OBSERVATION/SUBMISSION TO PLANNING APPLICATION

Case Reference: 324162

Re: Observation to the proposed development of a 220kV substation, telecommunications mast and underground electricity cable infrastructure with associated works.

Applicant: Bord Gáis Energy Limited

Joint Bay  
 General Arrangement Details

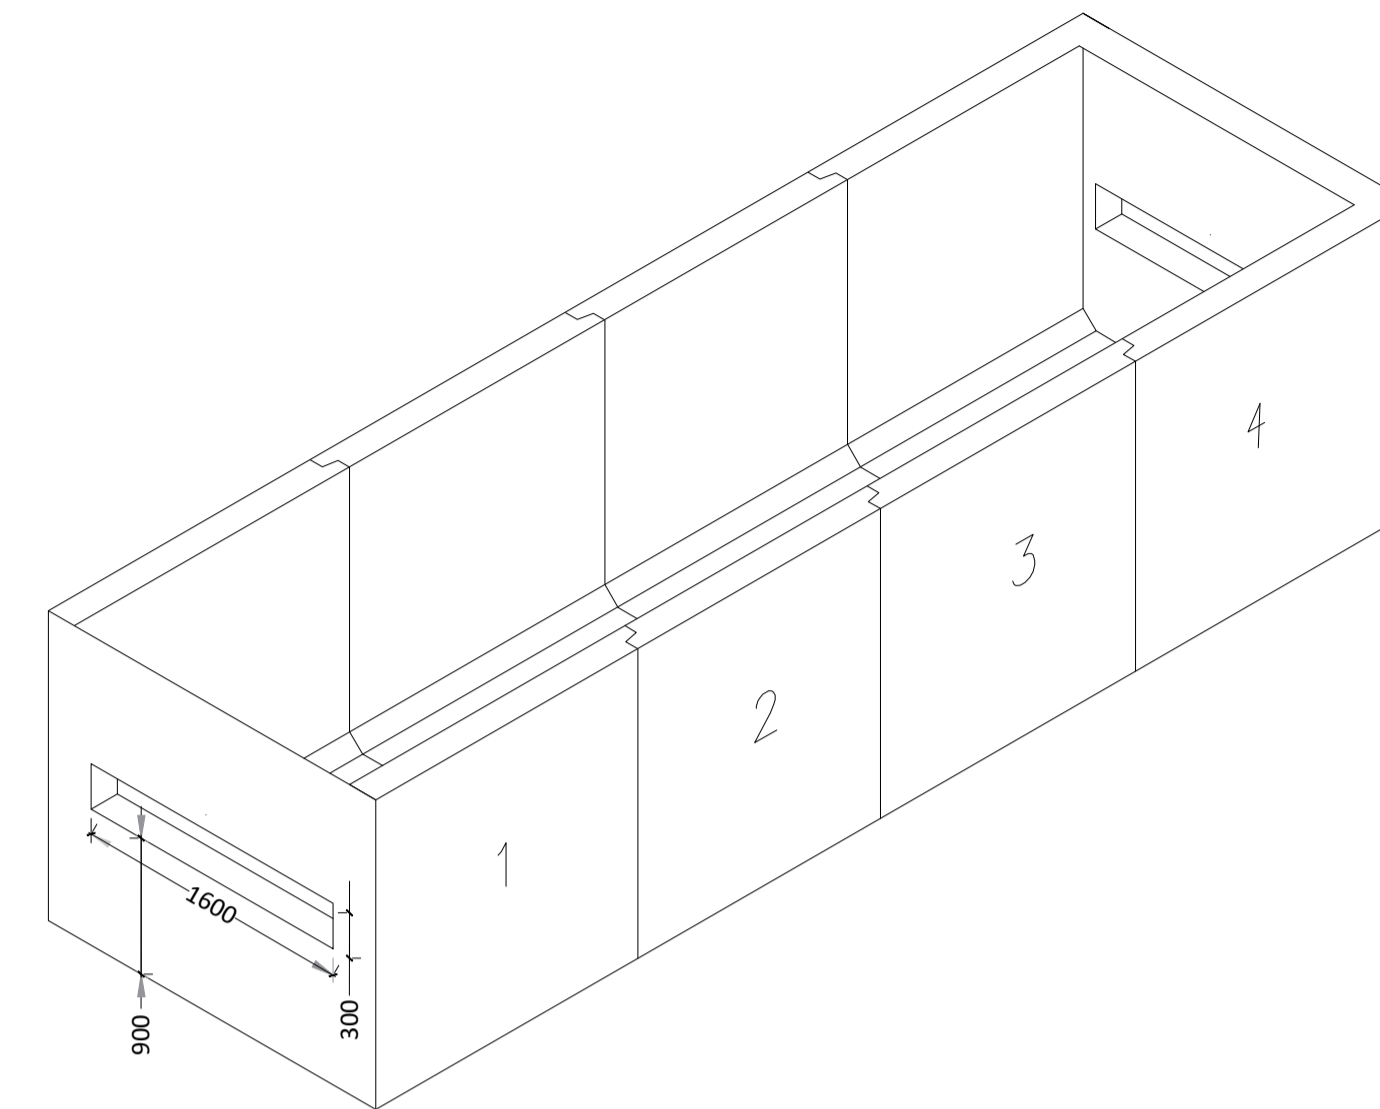
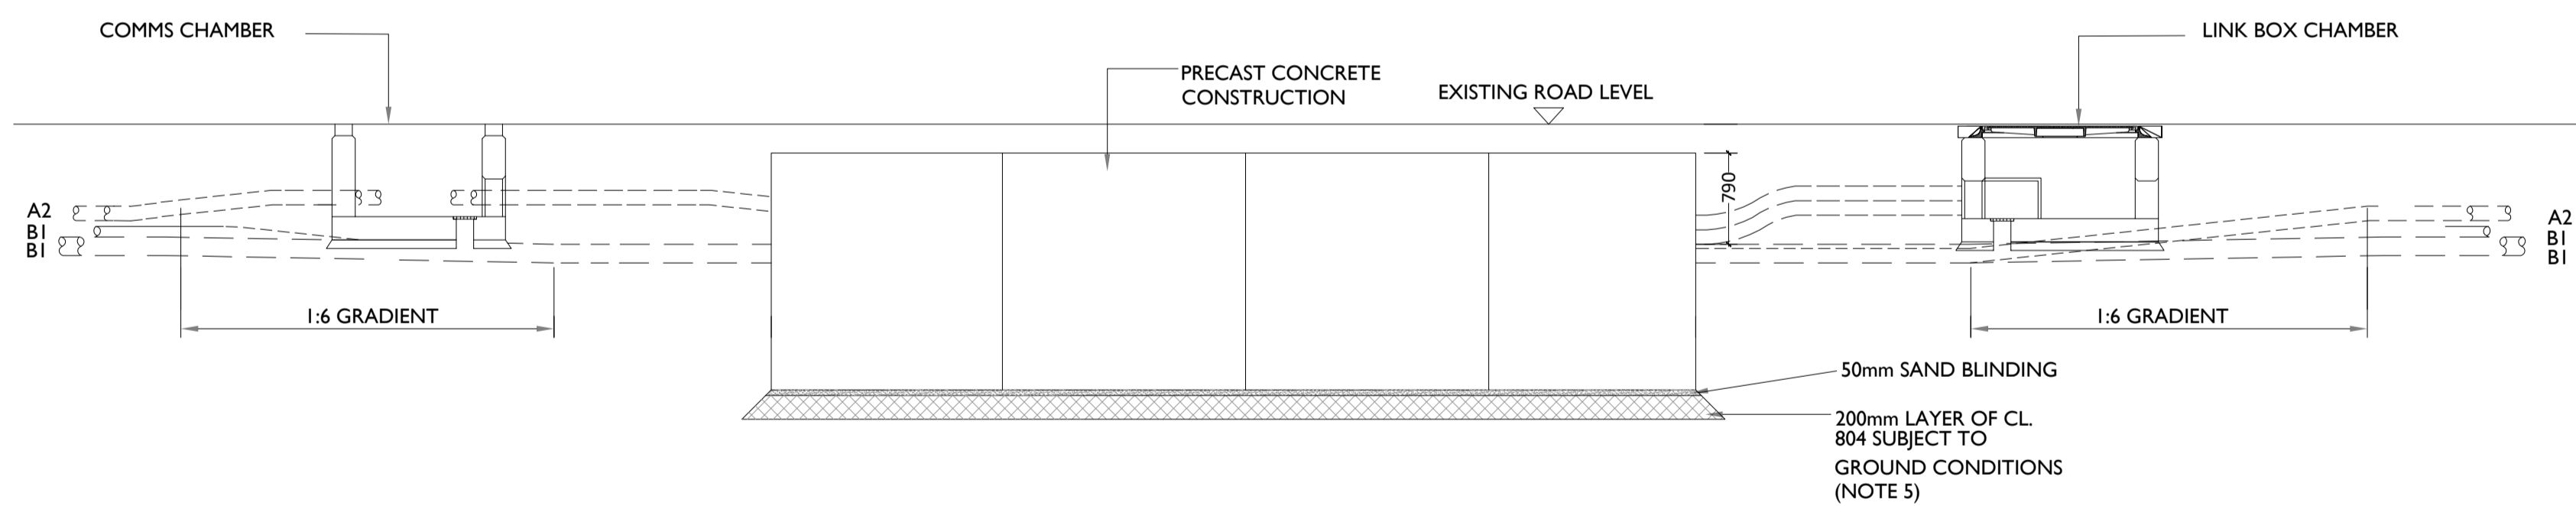
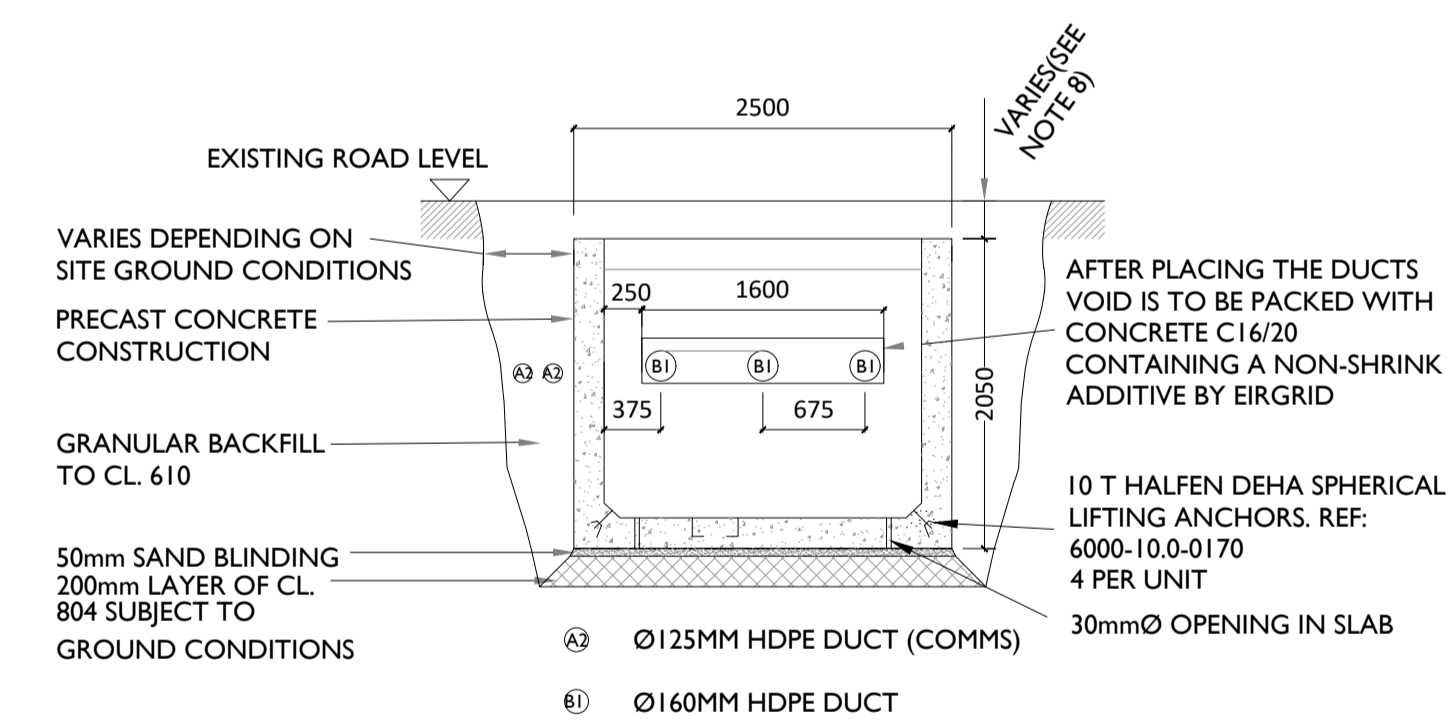
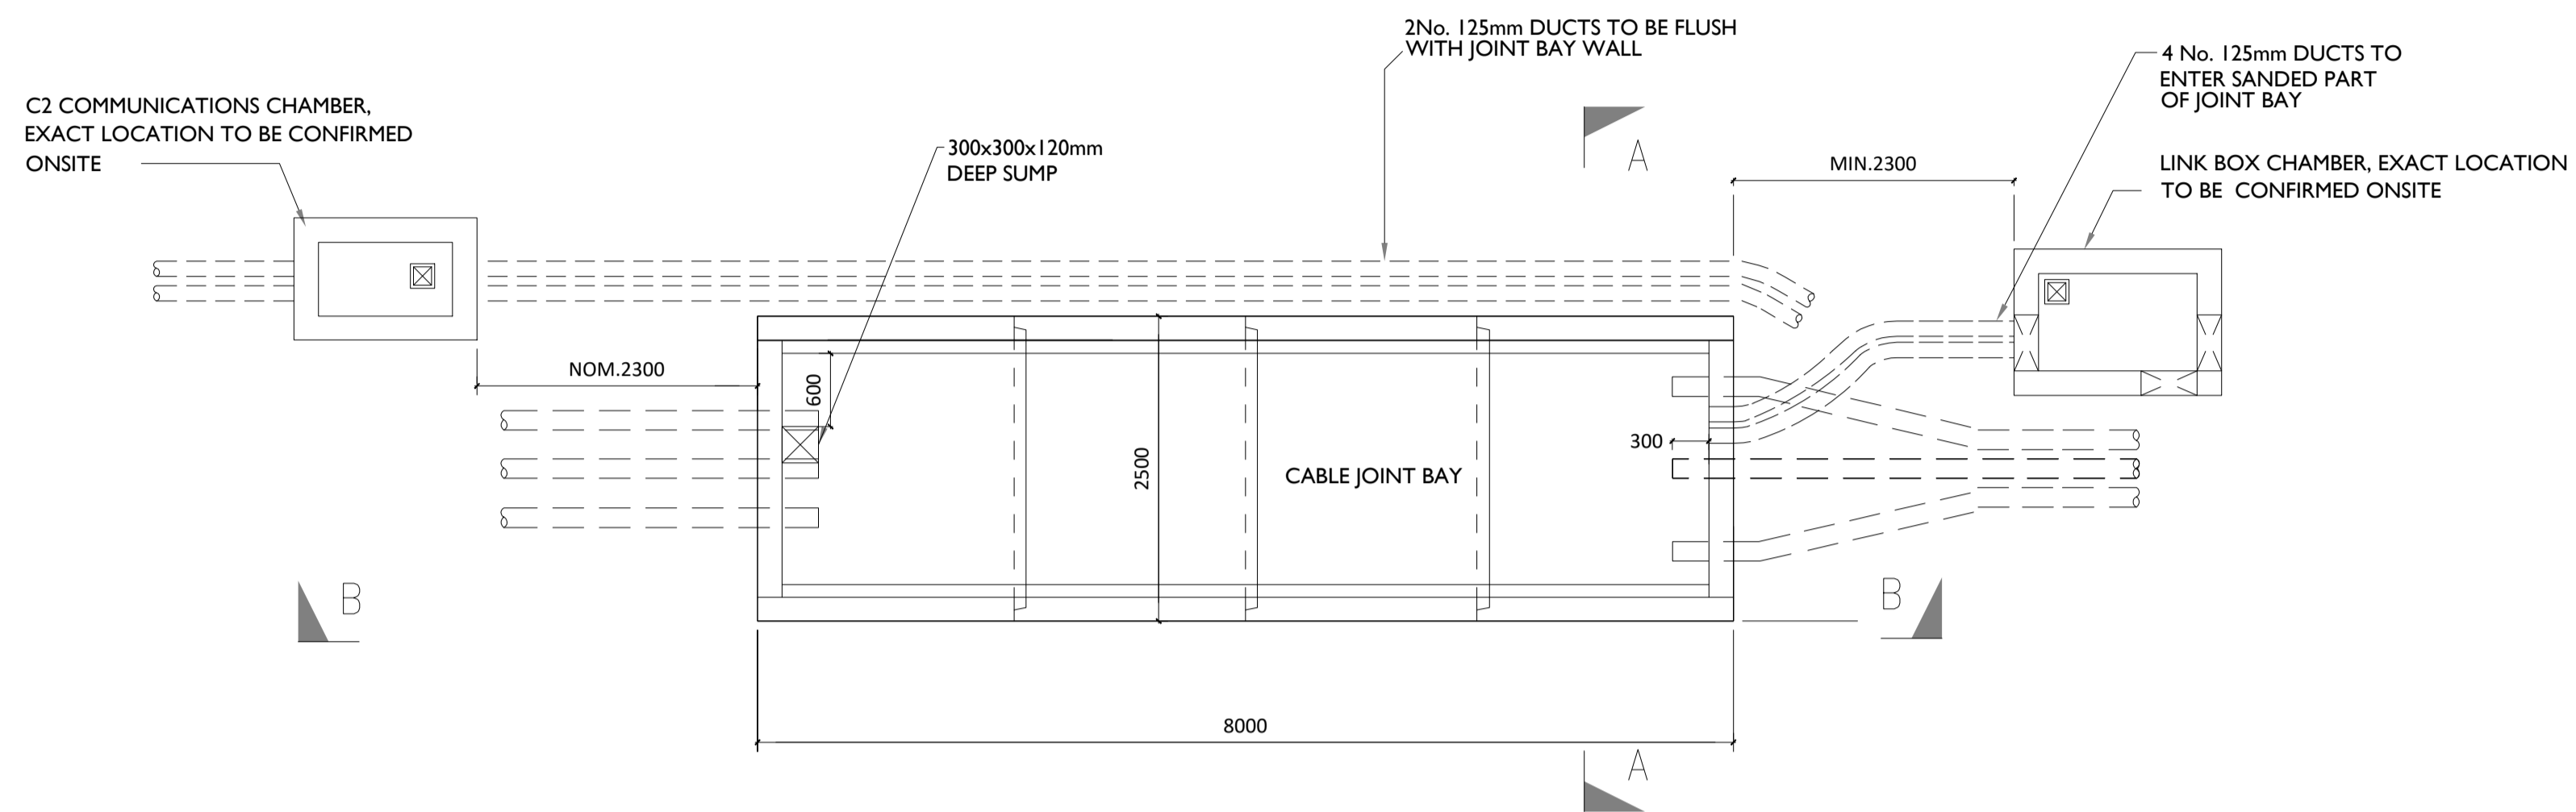
Of particular emotional, historical, and environmental importance to our family is a mature tree located beside the proposed grid connection works and proposed joint bay area. This tree stands on the site where my father was born in the early 1900s. While the original house no longer stands and only stones remain in the ground, the location remains deeply significant to our family history and connection to the area.

We are deeply concerned about the potential impact that the proposed joint bay excavation works, trenching operations, underground infrastructure, vibration, and heavy construction activity could have on the root system and long-term survival of this mature tree.

Given the scale of excavation proposed for the joint bay and associated underground cable infrastructure, we fear there is a real risk of damage to the root structure which could destabilise or permanently damage the tree over time. Once such damage is done, it cannot be reversed.
